Reference: **EIS Access Capability Statement**

We have been asked to review the revised entry and roundabout details proposed for the Dubbo Base Hospital.

**SITE PLAN
SITE PLAN - STAGE 4, GROUND AND LEVEL
1**

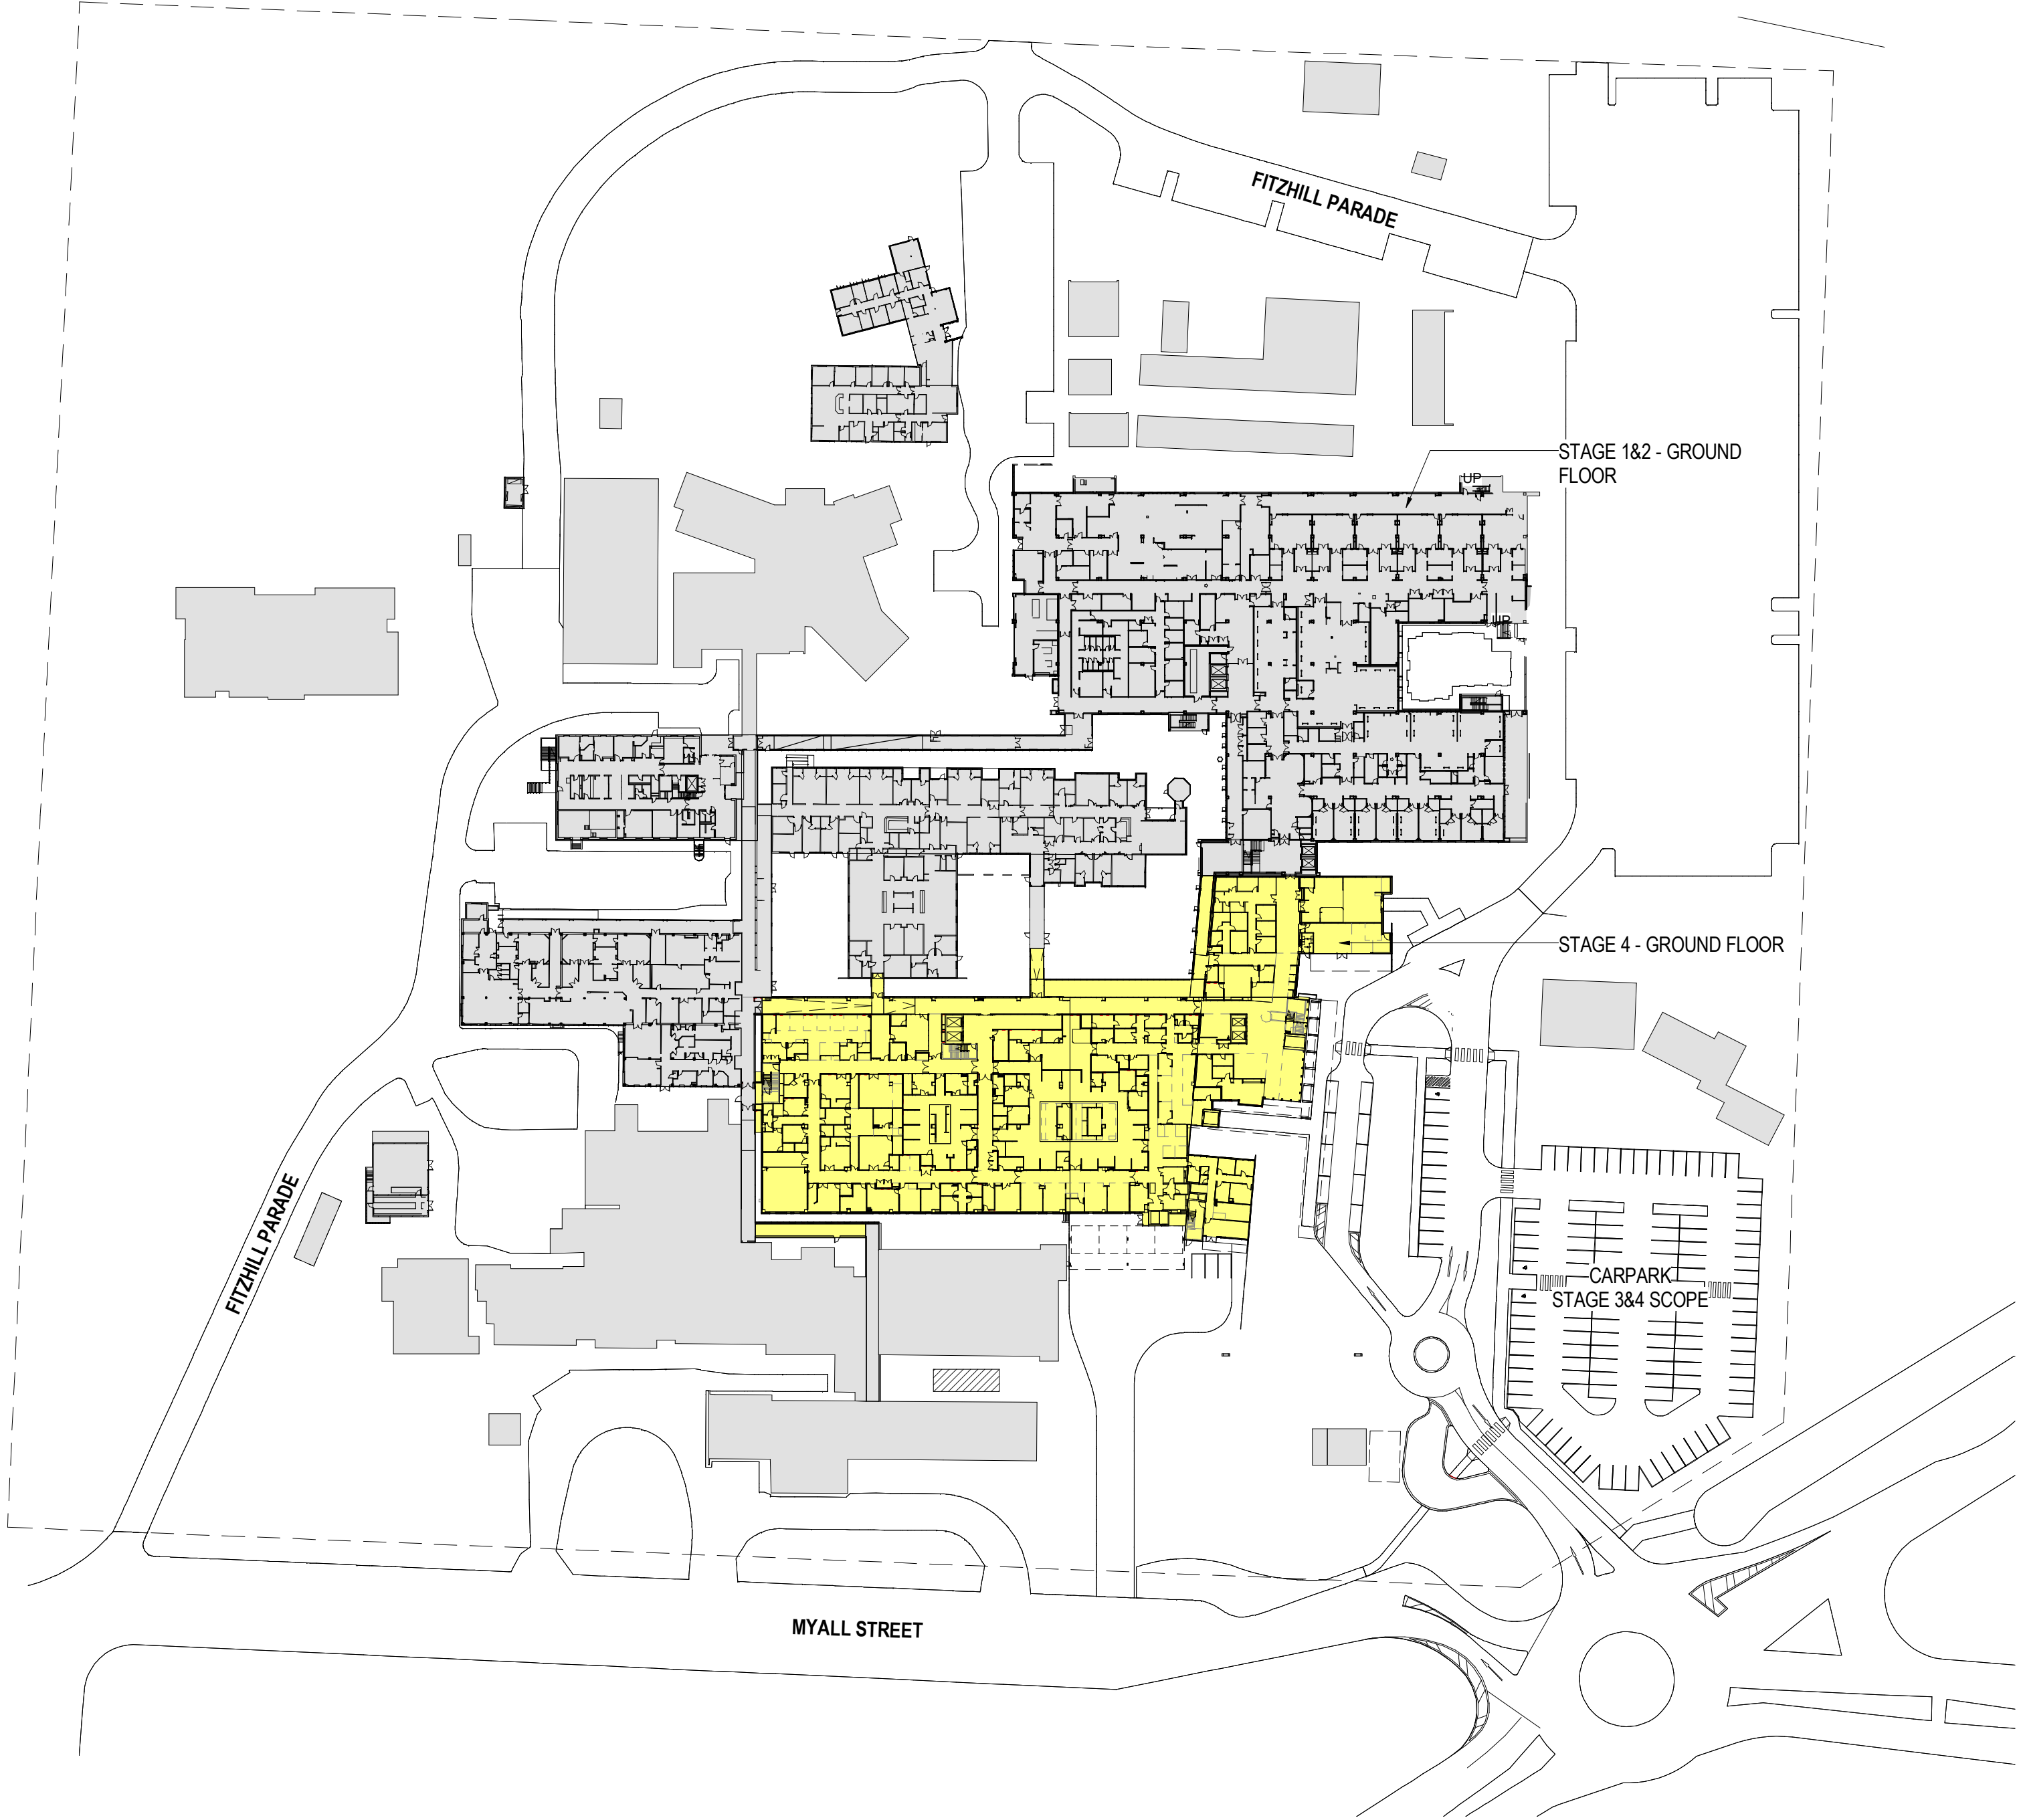
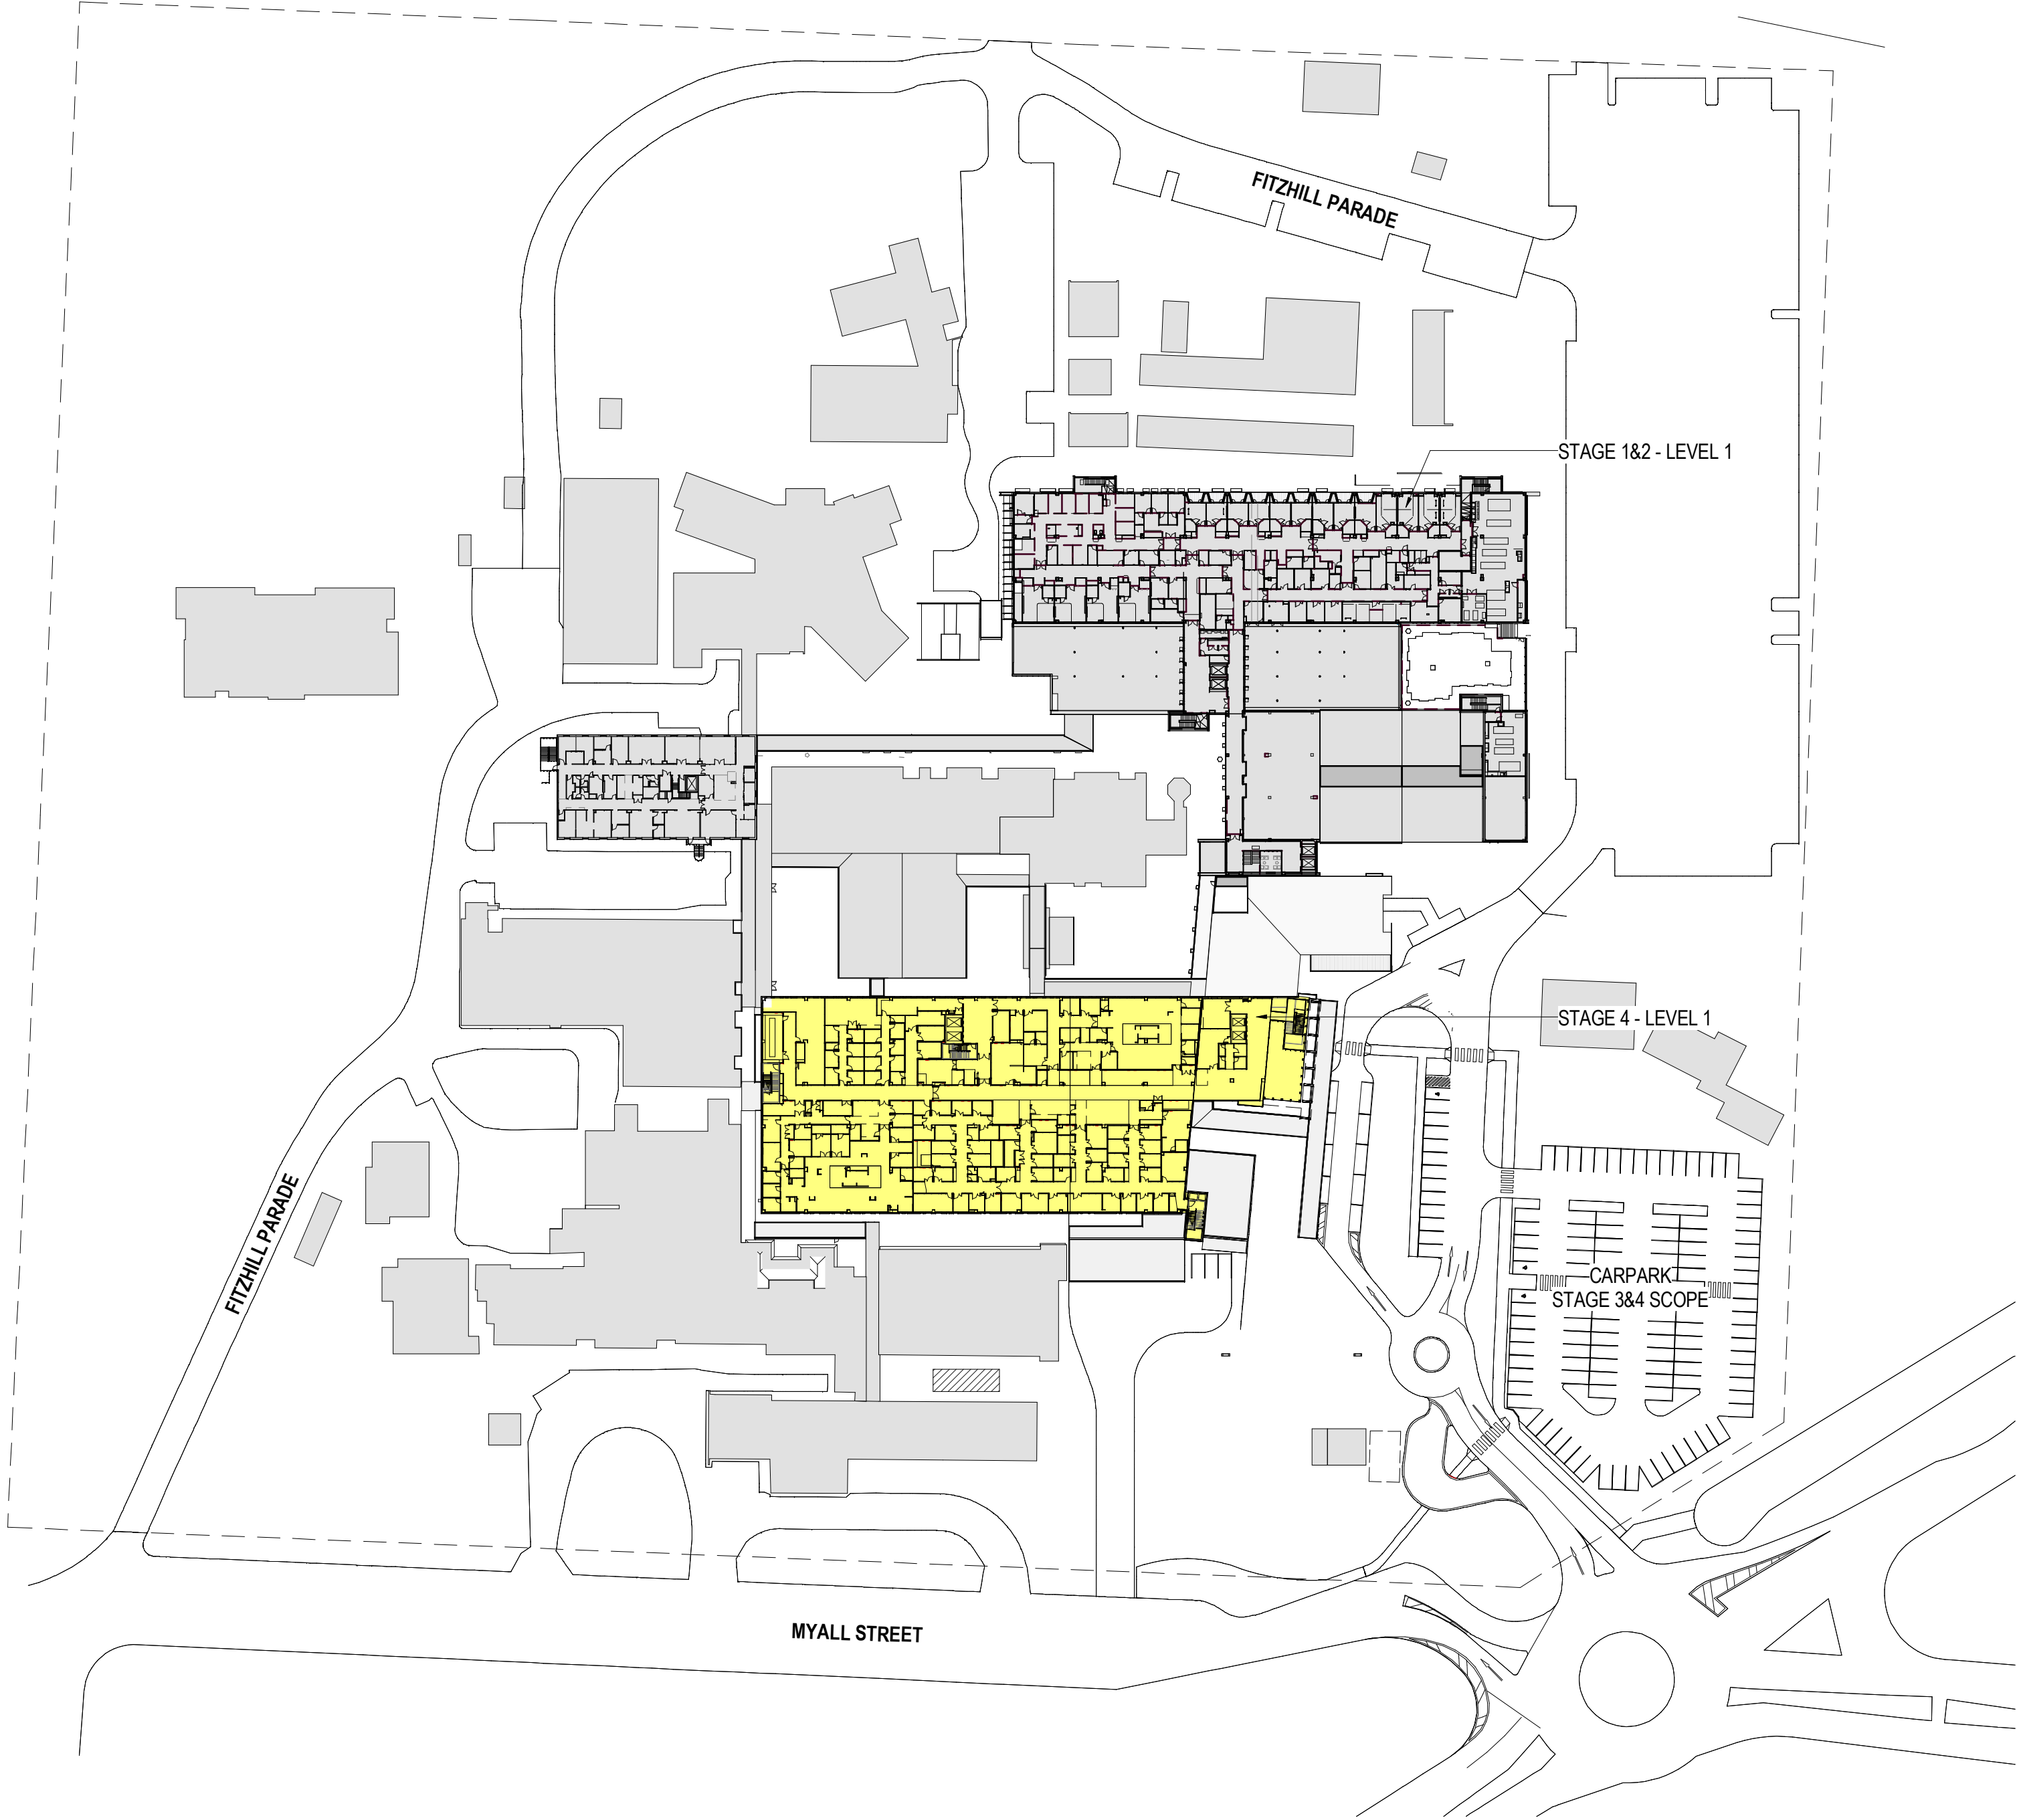
The detailing of the accessible parking space will need to include for a Kerb/pram ramp to transition from the shared zone to the raised path of travel pathway to the Principle Pedestrian Entrance.
